17 October 2019

contact: Planning & Development
reference: SSD-9143

SUBJECT: COUNCIL SUBMISSION - GOULBURN POULTRY PROCESSING PLANT
LOCATION: 52 SINCLAIR STREET, GOULBURN (LOT 22 DP750050)

Viewpoint 6

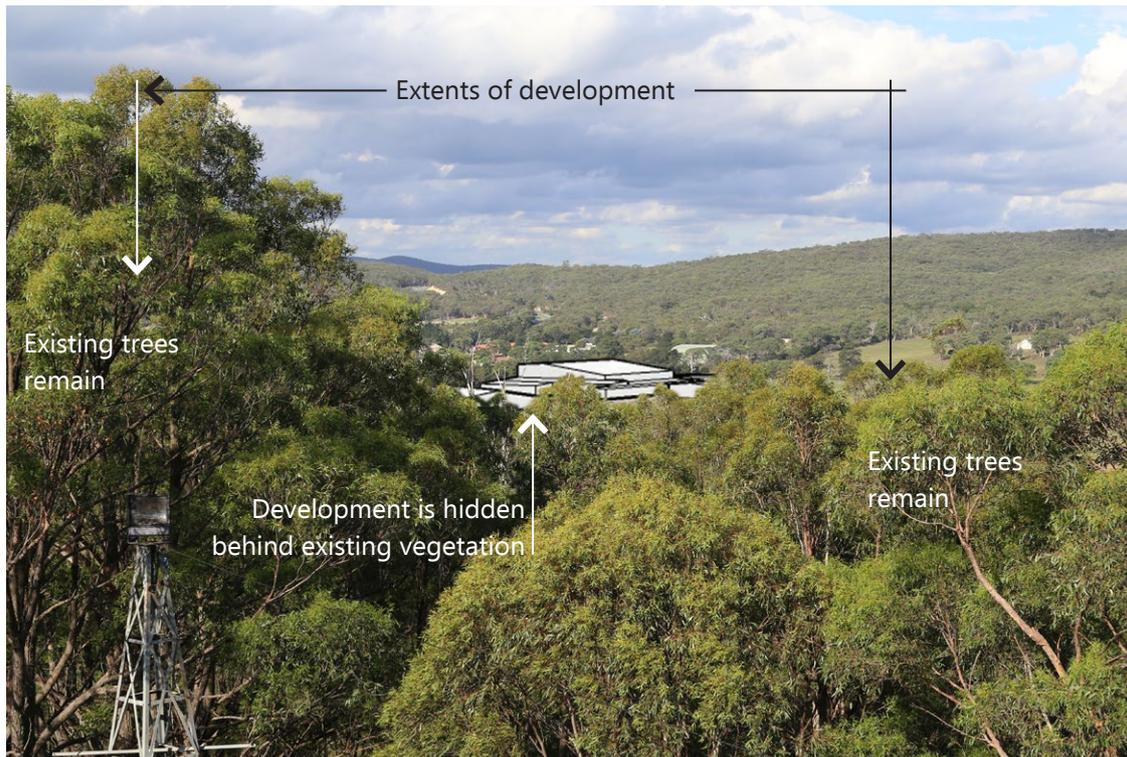
The main issue that has been lightly addressed is the view from the Rocky Hill Memorial and Museum which is a public viewing area and is associated with the history of the area, as well as being a war memorial and tourist attraction. The view from the memorial is arguably one of the more important views for consideration.

It is stated that the impact on this view is moderate, and that viewer's time is short. The importance of the use of the site and history are down played in the VIA. The impact on views from this site, given its use and local importance, warrant greater consideration. Notwithstanding, the overall recommendations in the VIA would address the impacts to some degree. Choice of colour scheme, building height and landscaping would be very important to mitigate the impact of the development from this view. In this regard, Council does not accept the choice of zincalume for any roof material. Roof material can be galvanised steel or Colorbond, so as to reduce the visual impacts to the locality.

Viewpoint 10

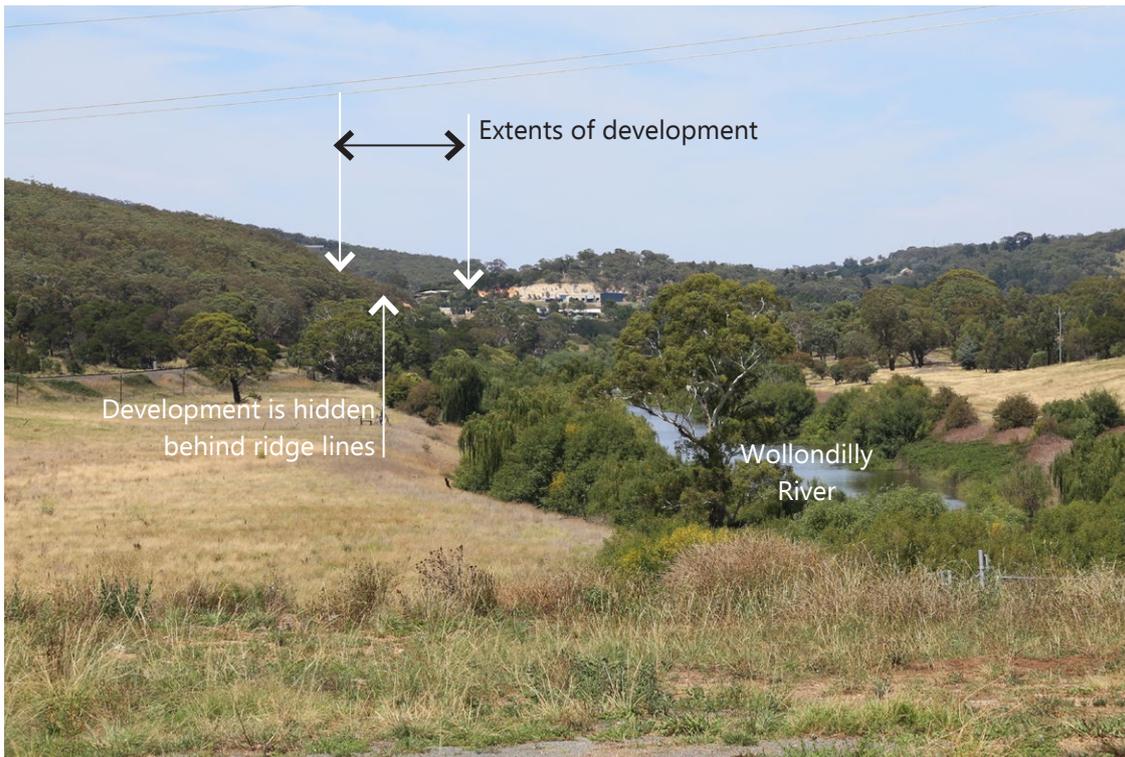
There would be an immediate impact on views from Common, Long and Chiswick Streets however, given the zoning, the potential for the development of this area for large footprint buildings was always likely. The VIA (Appendix H) only notes one 'regional' view which is from Wollondilly Avenue looking across the valley towards the site. The impact on the regional view is rated as low with a high visual absorption rating given the trees, existing commercial structures on Sydney Road and distance.
